Application No: FG/114/21/HH

Recommendation Report for Planning Permission for Works or Extension to a Dwelling

LOCATION: 23 South Drive
Ferring
BN12 5QU

PROPOSAL: Extensions and internal and external remodelling of existing dwelling to create a 4no. bedroom dwelling with double garage including single storey rear extension, replacement and reformation of roof to create second floor accommodation with rear balcony, associated landscaping.

Street Scene Elevations -
Existing & Proposed

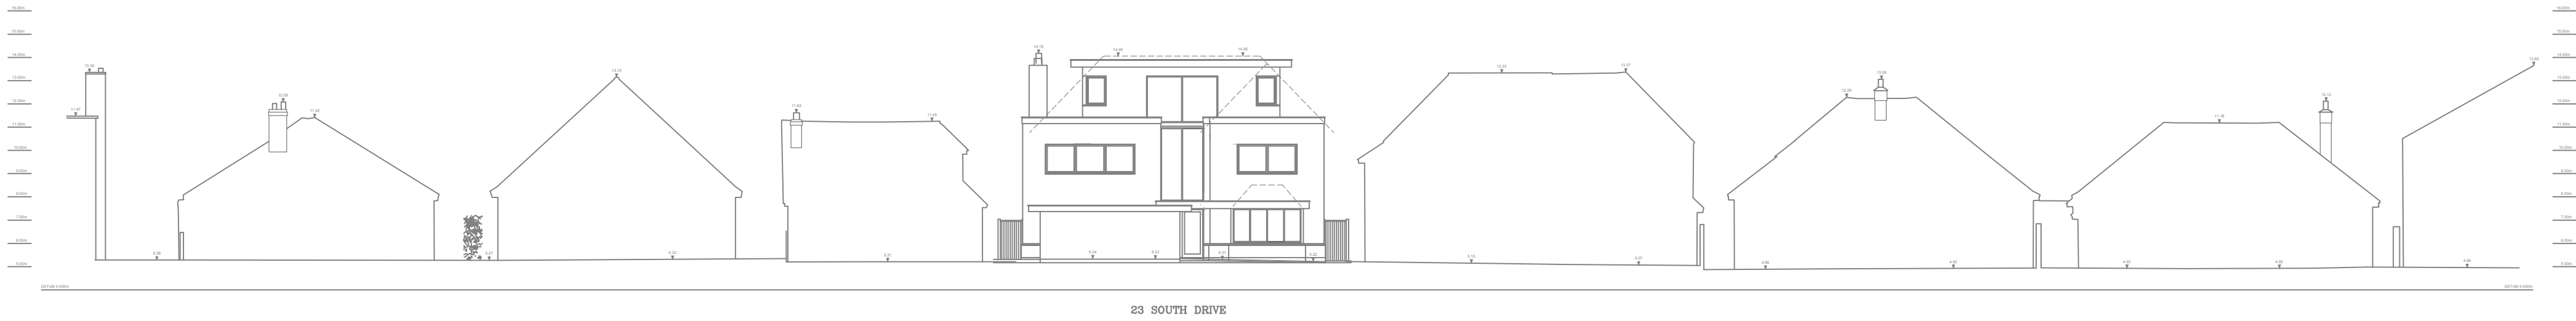
The principal elevation of the dwelling is situated approximately 22m behind the front boundary. As a result, the dwelling would not appear unduly dominant being well set back from the street scene. Whilst an additional level will be constructed, the proposed dwelling would not be taller than the existing dwelling at a height approximately 8.8m which is comparable to others within the street scene.

Elevations - Proposed

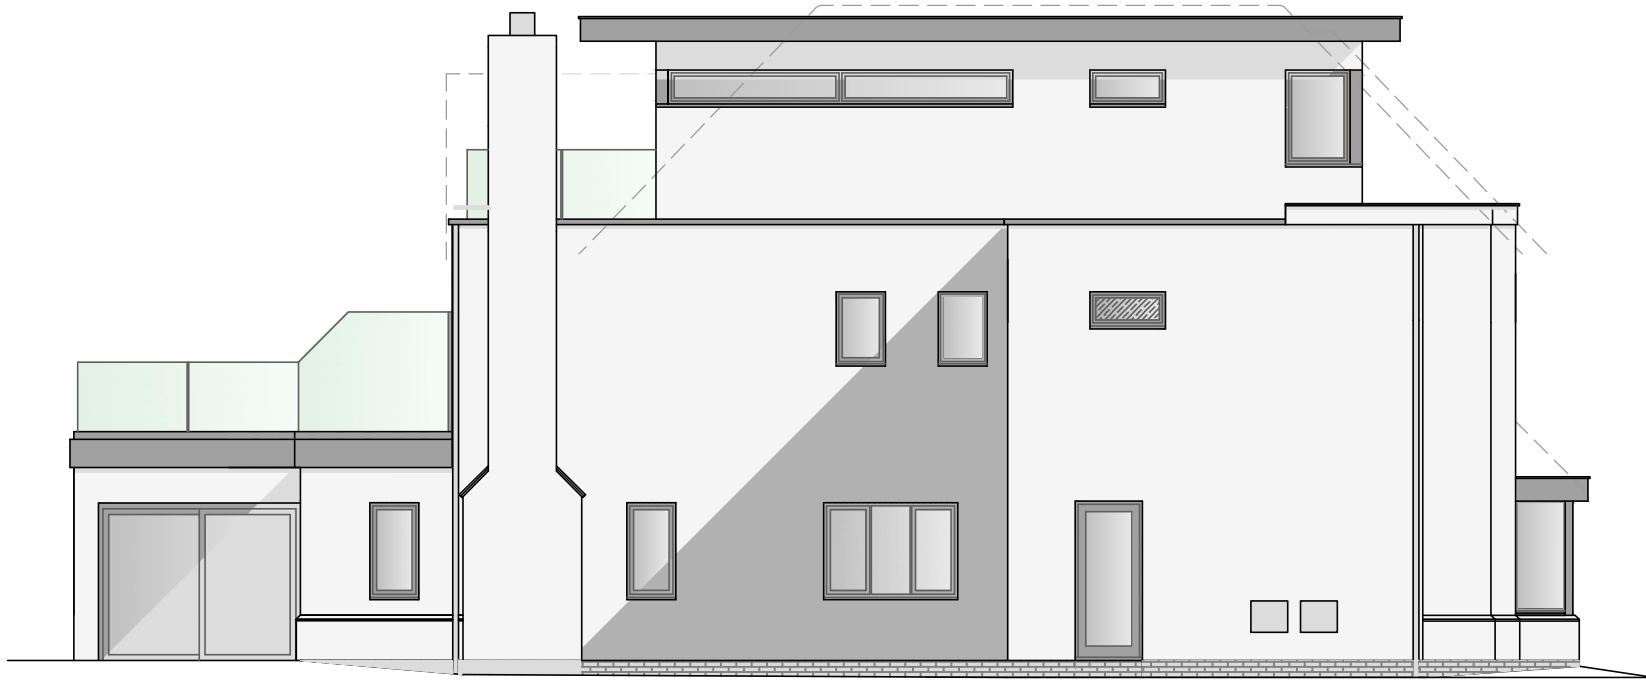
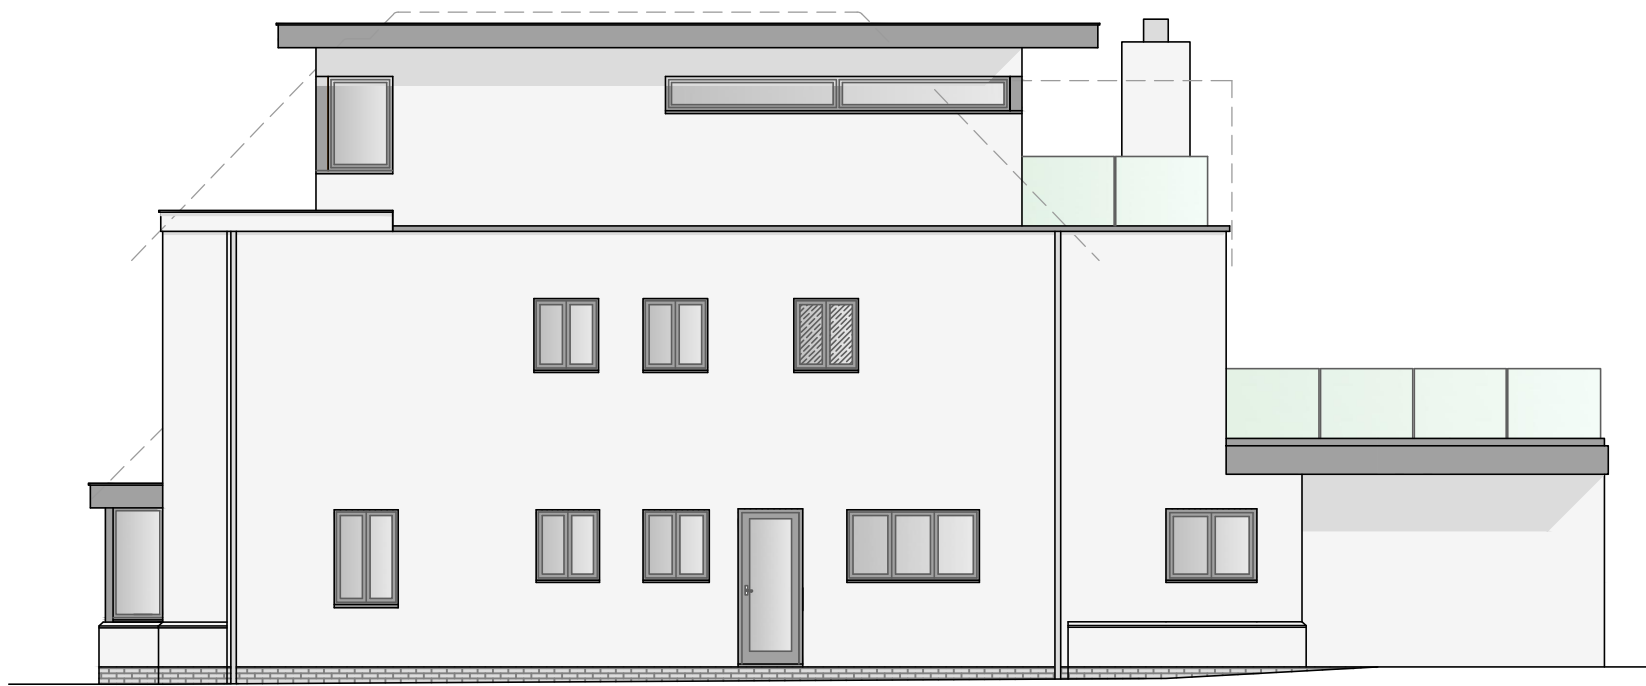
In addition, the materials will consist of render and cedar cladding decorative panels to the external elevations, with grey window frames, frameless balustrades and with similar materials present within the locality, it will not adversely impact the street scene.

The top floor balcony is set within the roof with a depth of 2.4m. Only limited views could be achieved from the proposed balcony towards 21 South Drive due to the positioning of the balcony and due to the proposed chimney which would further obstruct views. With No 25 located further south, views over the garden of the property are largely restricted. There would be no direct views into neighbouring windows and with the addition of screening to the side elevation views would be predominately to the rear of the host dwelling and beach.

Fenestration changes to the side elevations are not extensive restricted to some additional windows to the top floor. These are at a high level and will not result in additional overlooking.

- 3 Balcony screening shall be installed to the east and west elevations to both the first and second floor balcony and shall at all times be obscured glazed and to a height of 1.7m. The screening shall be installed prior to the first use of the balcony and be retained thereafter in perpetuity.

Drawing Name
Garage Plan and Elevations - Proposed

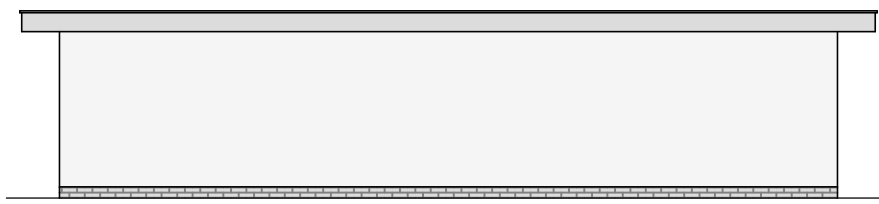
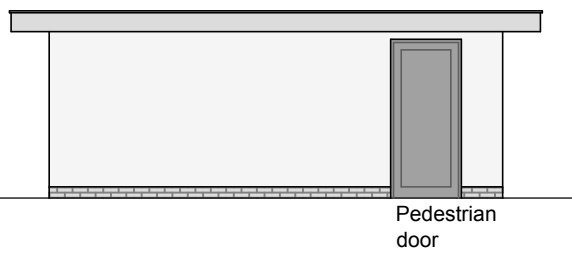
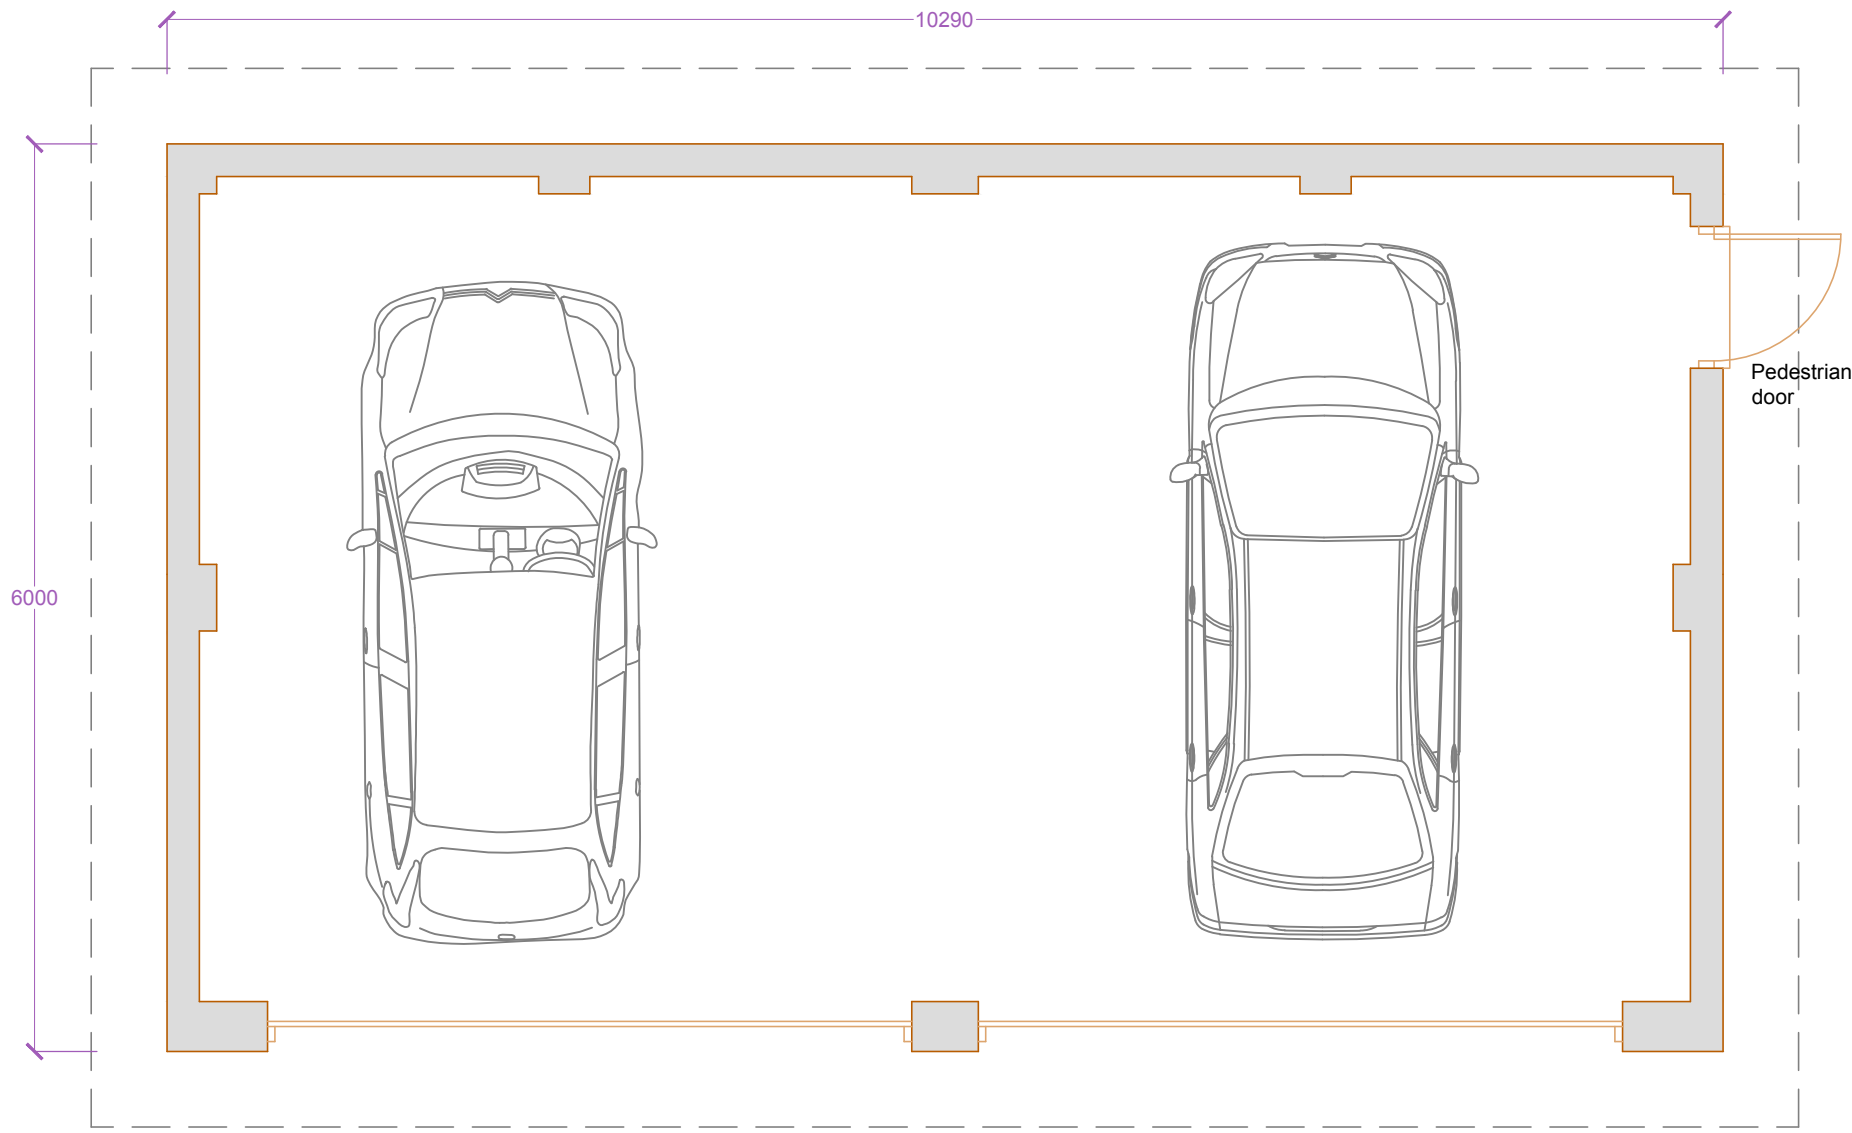
A double garage is also proposed which is located around 4m at its narrowest point from the front boundary. The garage will extend along the eastern boundary. It will have a flat roof and a modest height at 2.45m. There are other garages within the locality which are located towards the front of the site and the siting is not considered out of character. It will utilise an existing access.

The proposed garage due to its siting to the front boundary of the property and with a modest height will not result in unacceptable harm upon amenity.
